Planning Application Old Road Chatburn 3/2022/0500.

**Planning Application Reference No.:** 3/2022/0500

**Address of Development:** Land off Old Road, Chatburn, Clitheroe.

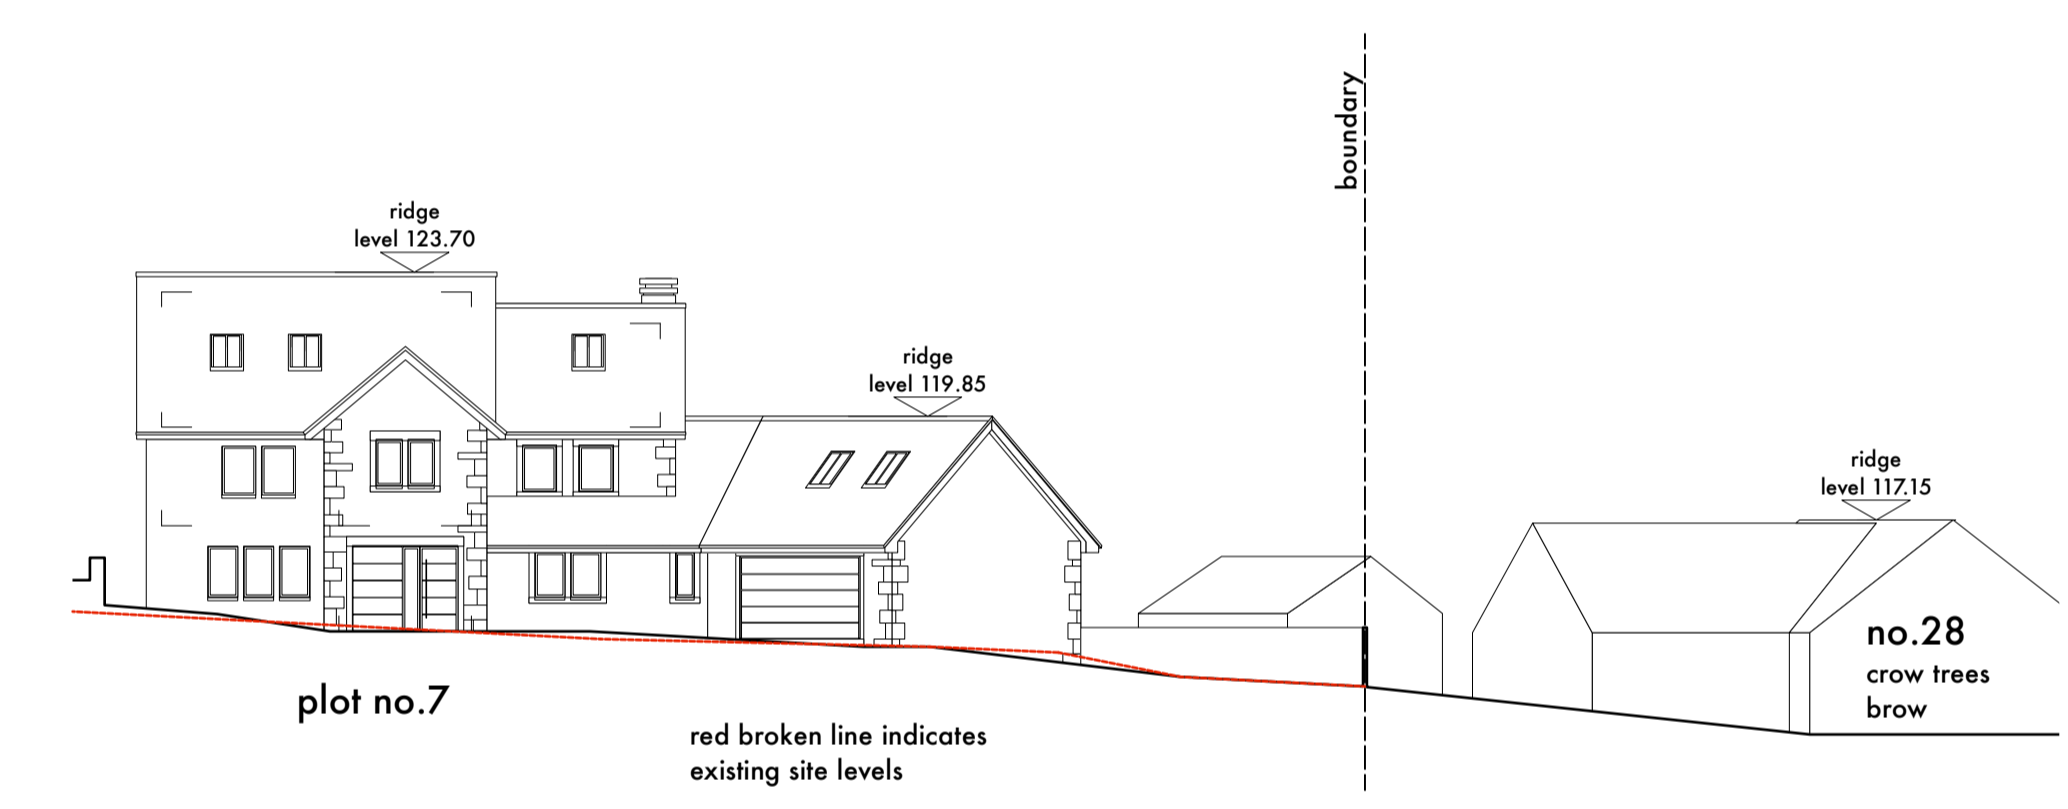
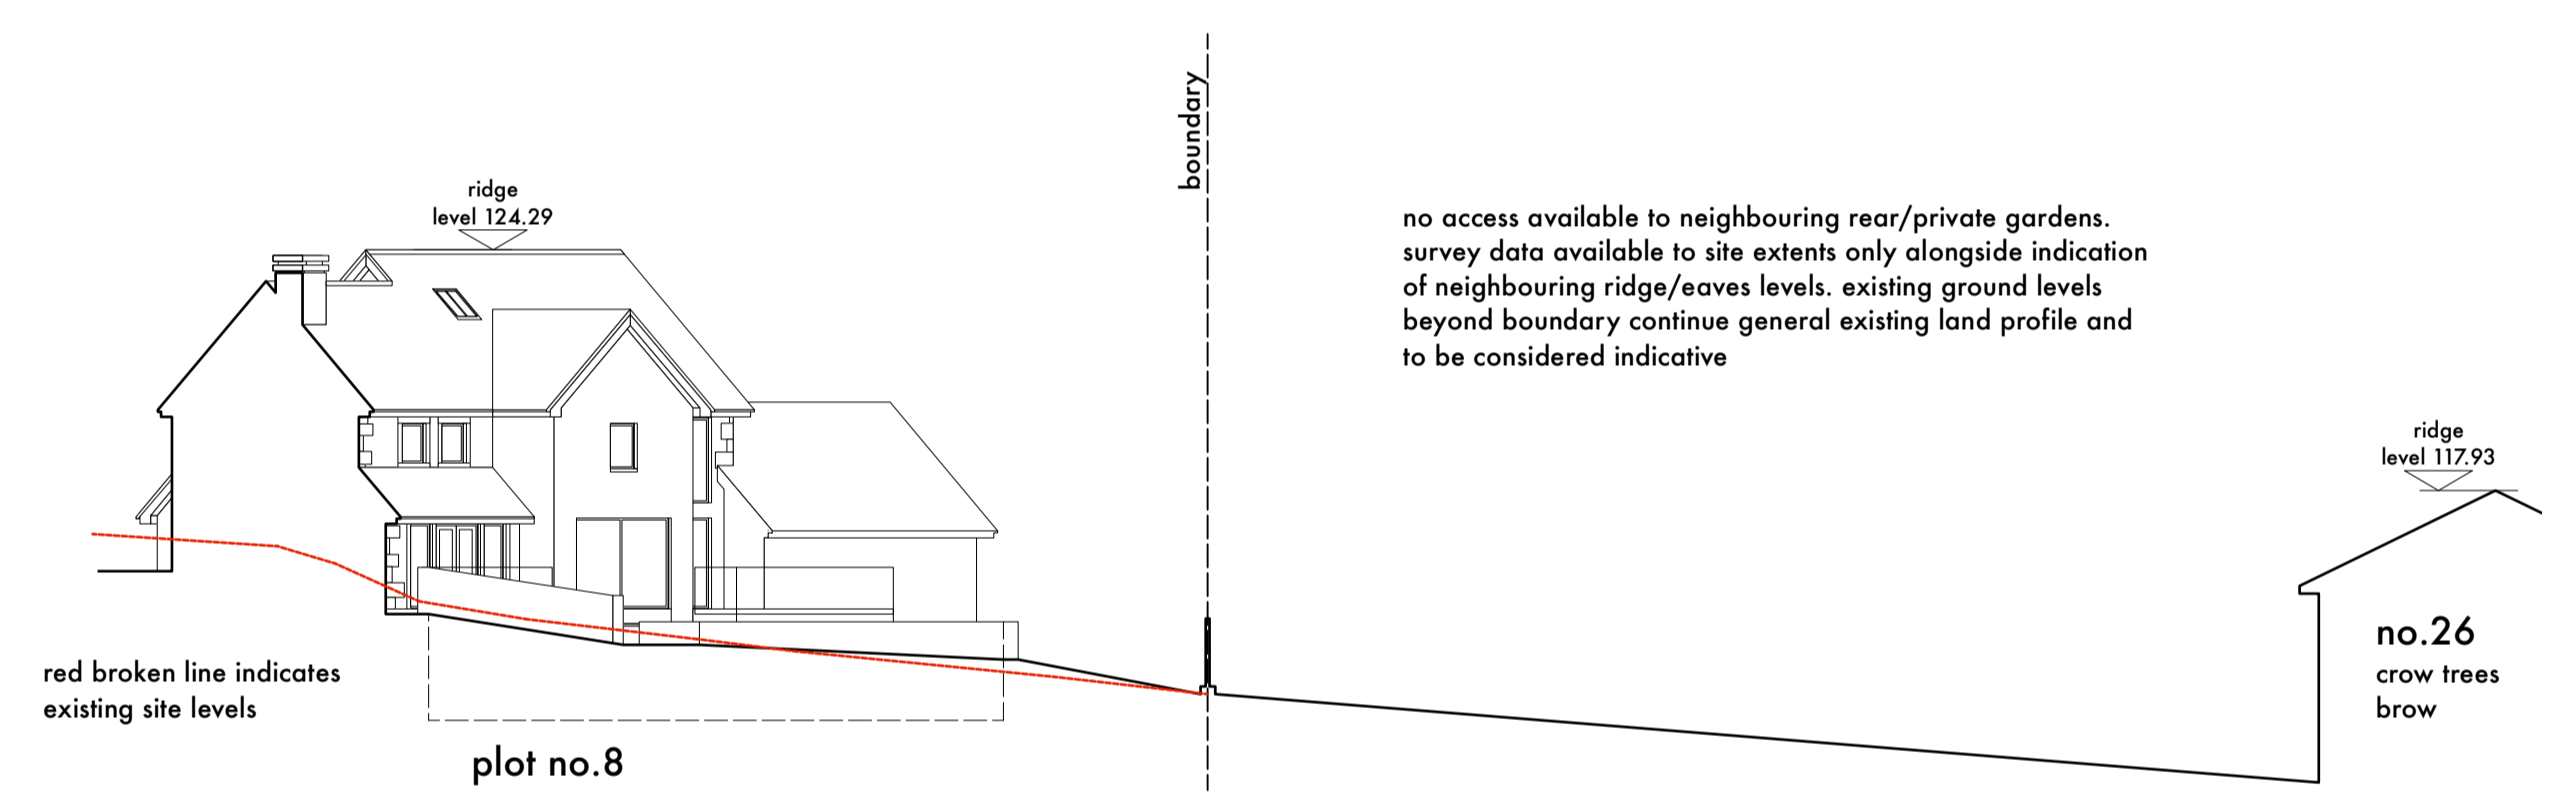
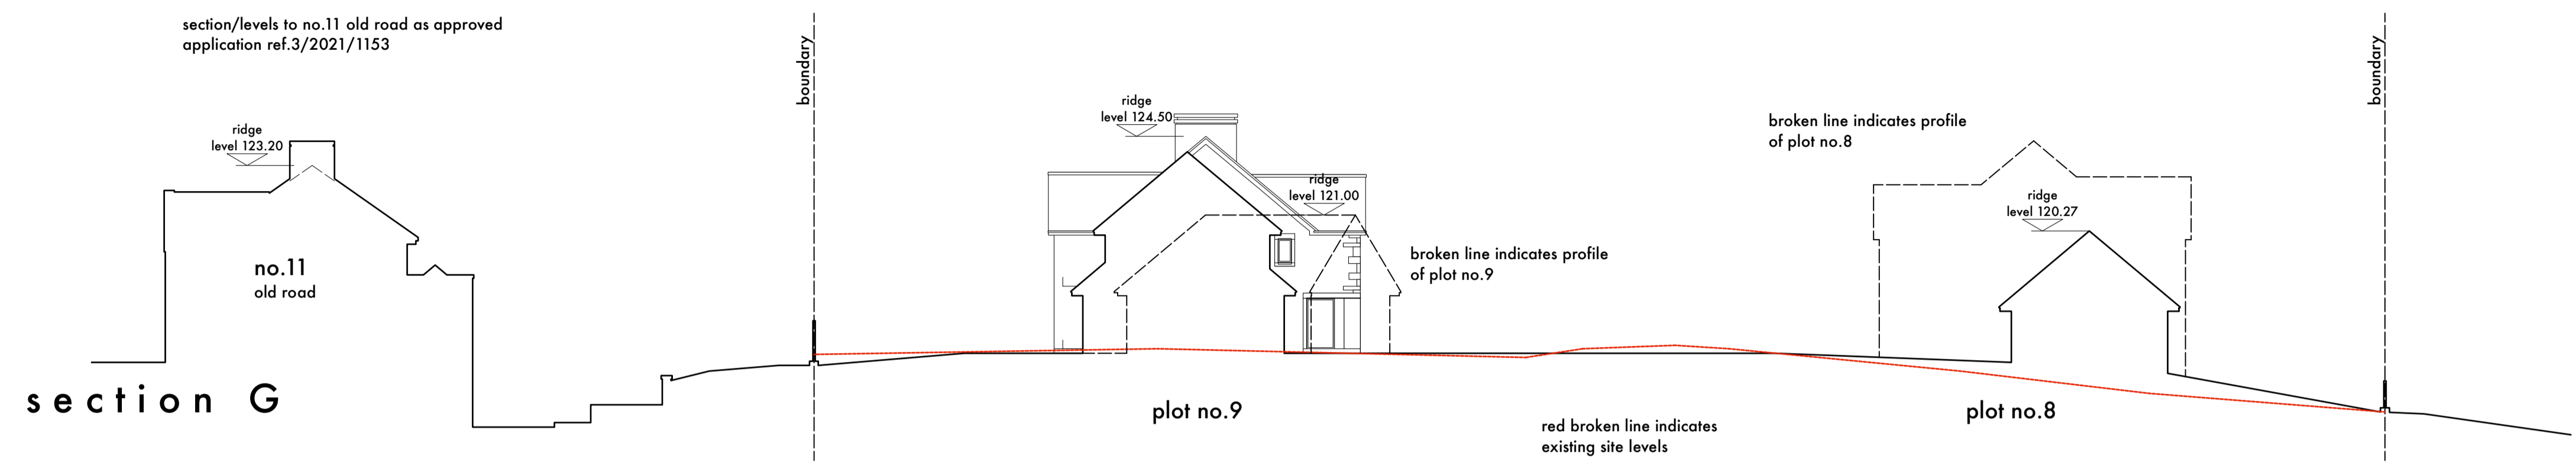
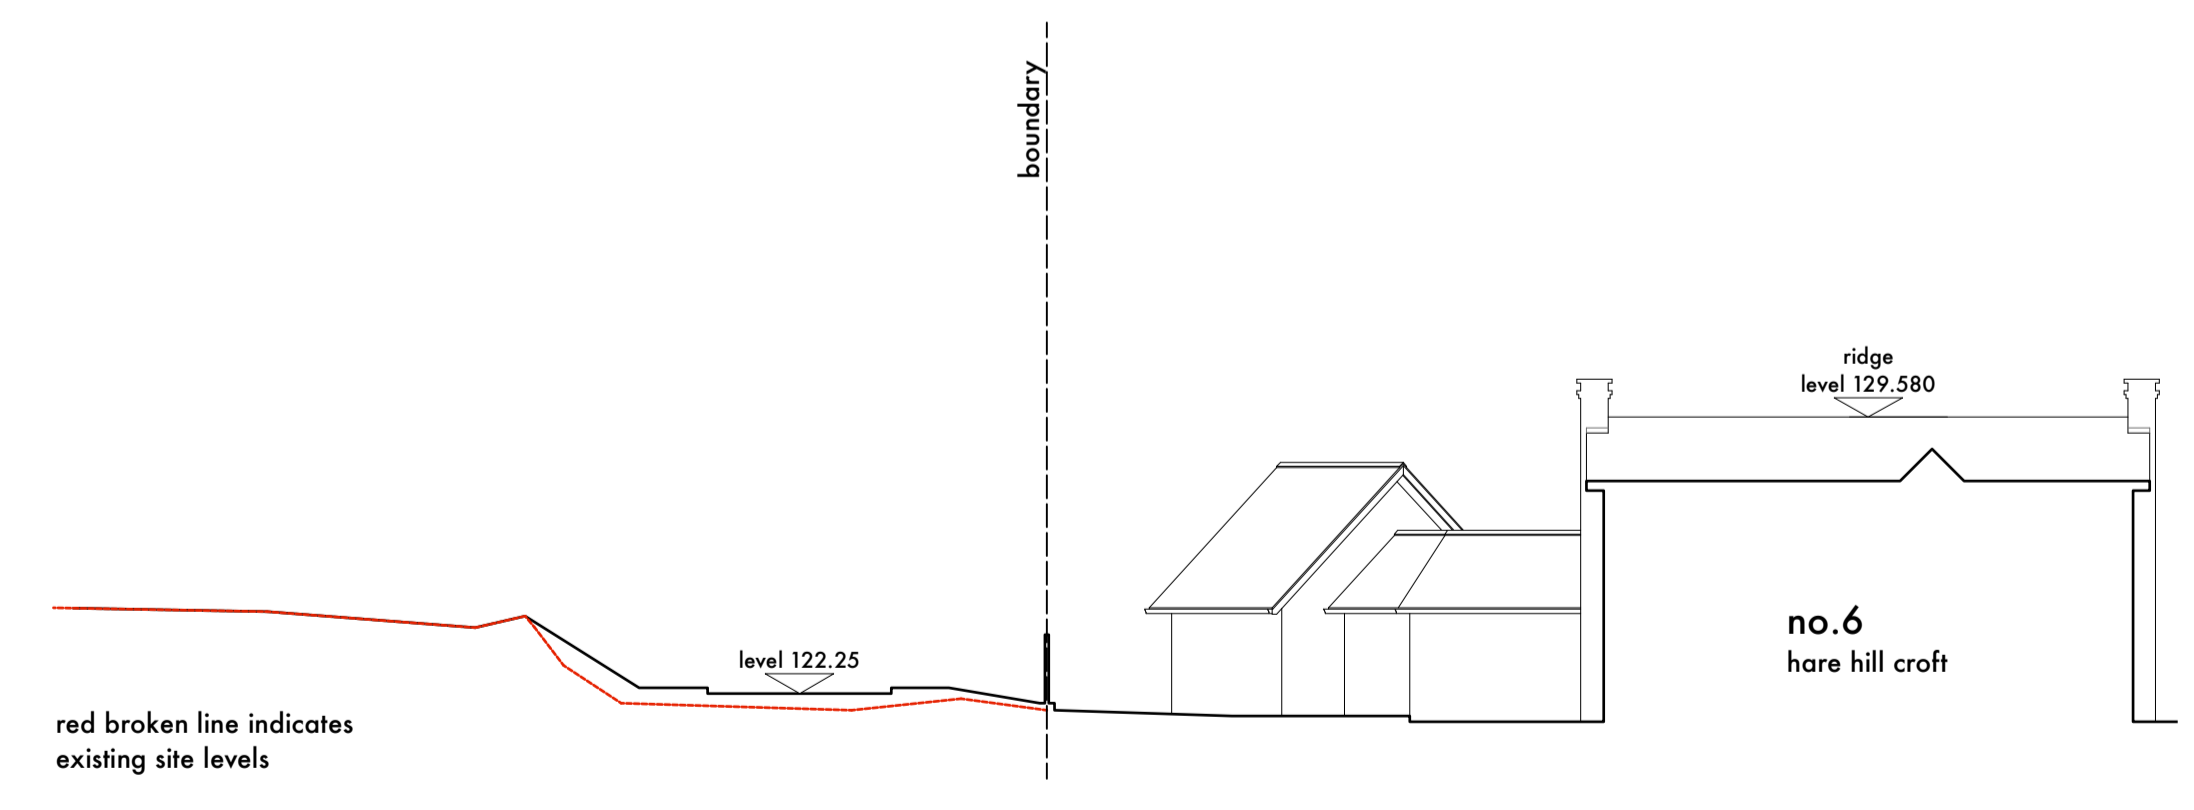
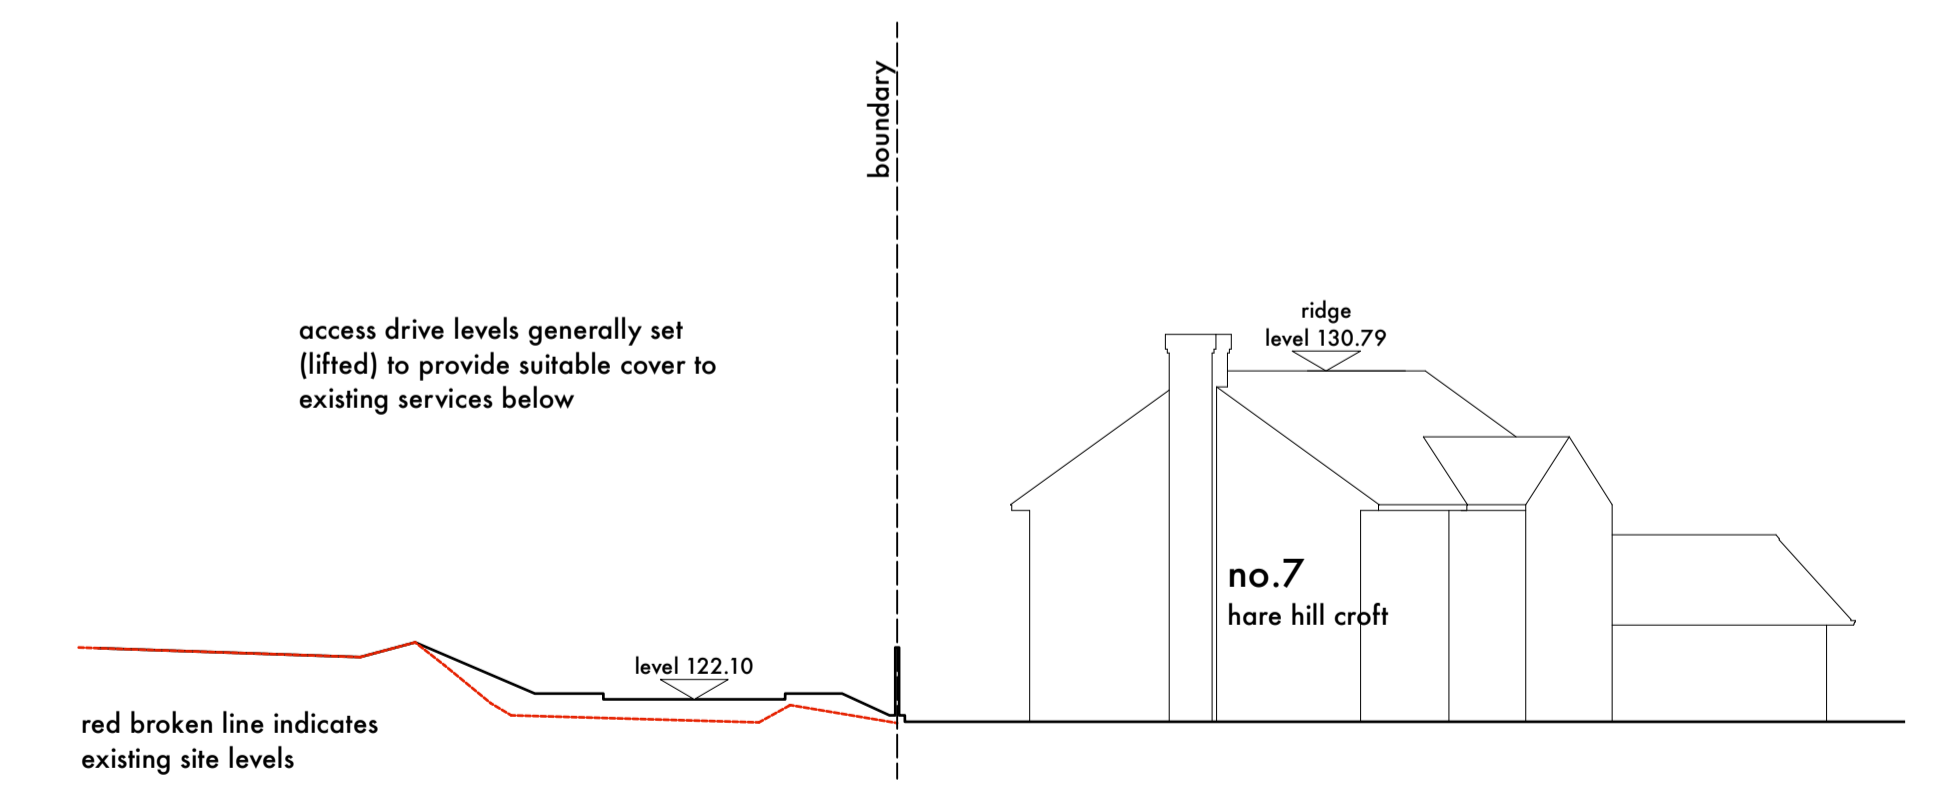
. *Section 1.* This does not illustrate the relation of the proposed development to either the new house (approved but not yet built – no 11 Old Rd) nor the relation to no.9 Old Rd.

. *Section 2.* This does not illustrate the relation of the proposed development to any of the properties on Crow Trees Brow. This would indicate how the privacy and overlooking would be affected.

. *Cross section from West to East.* I think a cross section is needed to illustrate the proposed fall from the top of the site to where the surface water and foul drainage meets the drain on Crow Trees Brow. This would be informative as it is not clear from the drainage drawings.
